Application # 0750017913 R

COUNTY OF HARNETT LAND USE APPLICATION

MILLENNIUM HOMES, LLC.
THE CAMBRIDGE
LOT # 251 CRESTVIEW
SCALE: 1"=50'
40

**RE: Harnett County Land Use Application HTE# 07-5-17913 Lt#251 Crestview Est.
THE# 07-5-17912 Lt#250 Crestview Est.**

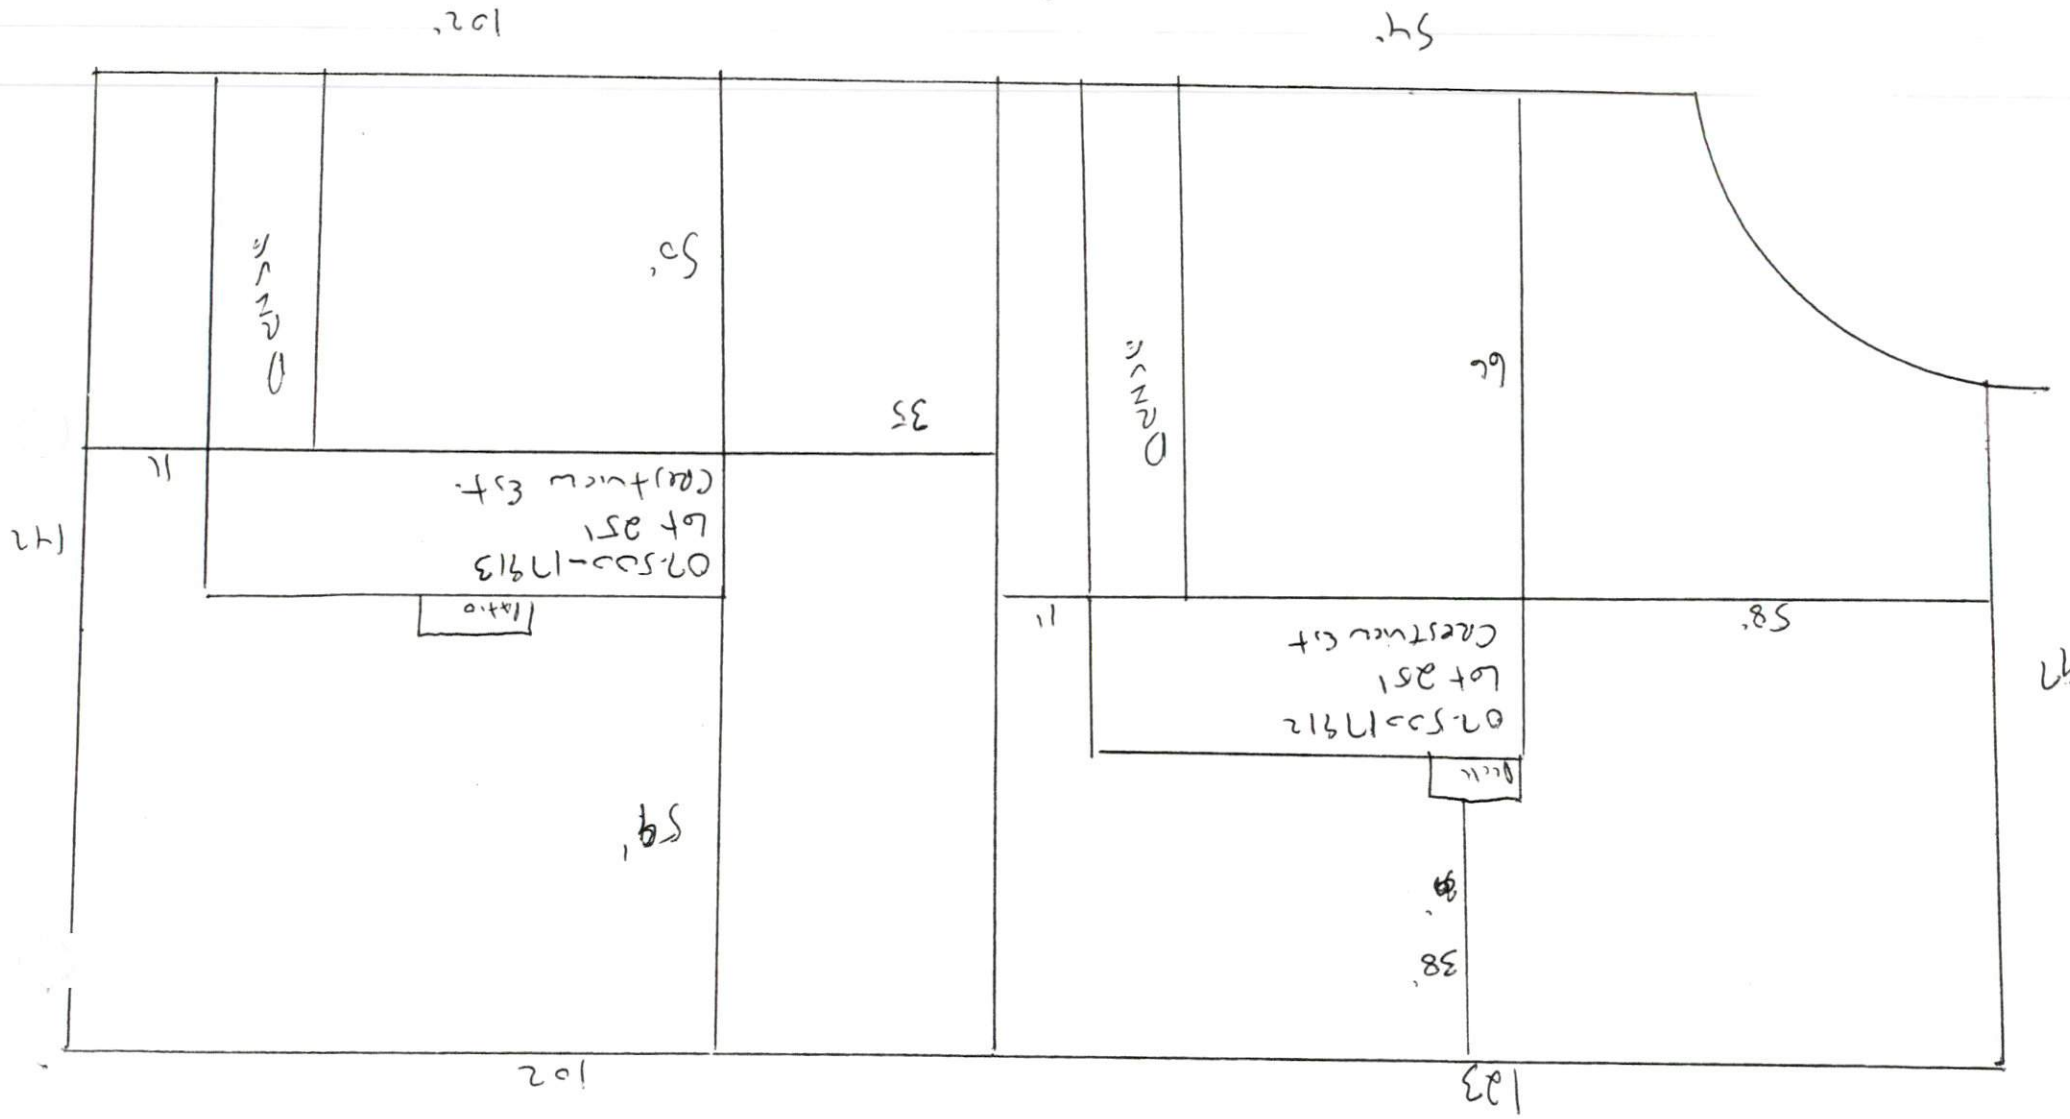
- 1. Property lines/corners not marked or labeled
- 2. House corners not marked or labeled
- 3. Directions not clear to property
- 4. Property needs brush or vegetation removed
- 5. Backhoe pits required
- 6. Other *Please move house location as shown on attached sheet and submit new plot plan with changes to Central Permitting.*

MILLENNIUM HOMES, LLC.
THE CAMBRIDGE
LOT # 251 CRESTVIEW
SCALE: ~~1" = 50'~~
1" = 40'

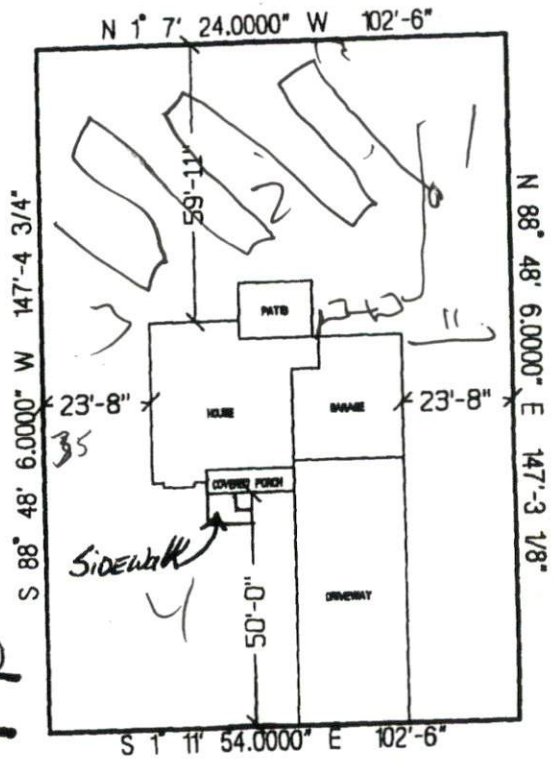
Minimum	Actual	Comments:
Front	35	50	<u>Comp # 080232 7/19/07</u> <u>7/19 move house porch</u>
Rear	25	59'-11"	
Side	10	23'-8" 11"	
Corner/Sidestreet	20		
Nearest Building on same lot	10
